## **DDA Compliance Statement – Authority Response to Stage 2 Submission**

**Project: West Sydney Stadium**

**JOB No: 00167-17**

**GA PLAN
SERVICE LEVEL
LEVEL 00 - OVERALL
RL 9.17**

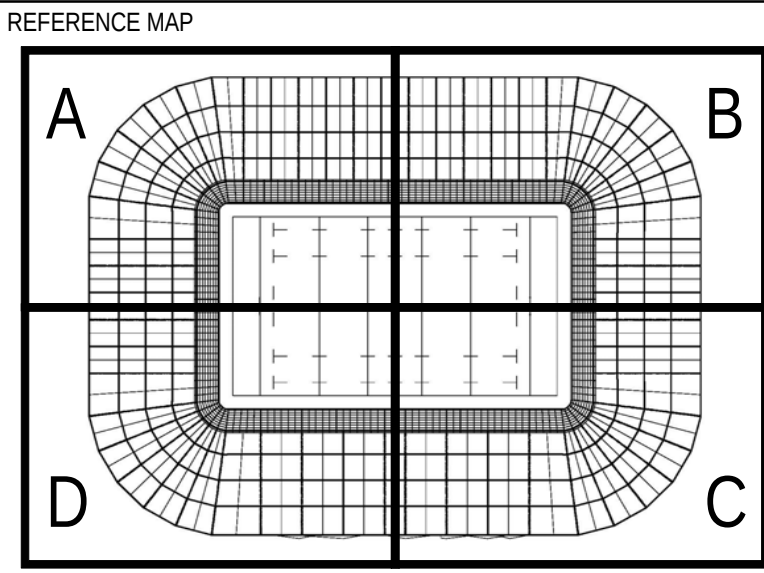
*The design should include integrated ramps that offer equally celebratory access between the lower public domain and the upper exterior stadium podium.*

Lift access is provided to the South East of the allotment as the level difference is too great to provide ramped access within the maximum permitted 3.6m rise allowable under BCA/NCC Clause D3.11, the North East and North West provides at grade access to the concourse. Compliant access will be provided to and within the building meeting the requirements of DAPS, BCA/NCC and Australian Standards and will be confirmed during design development.
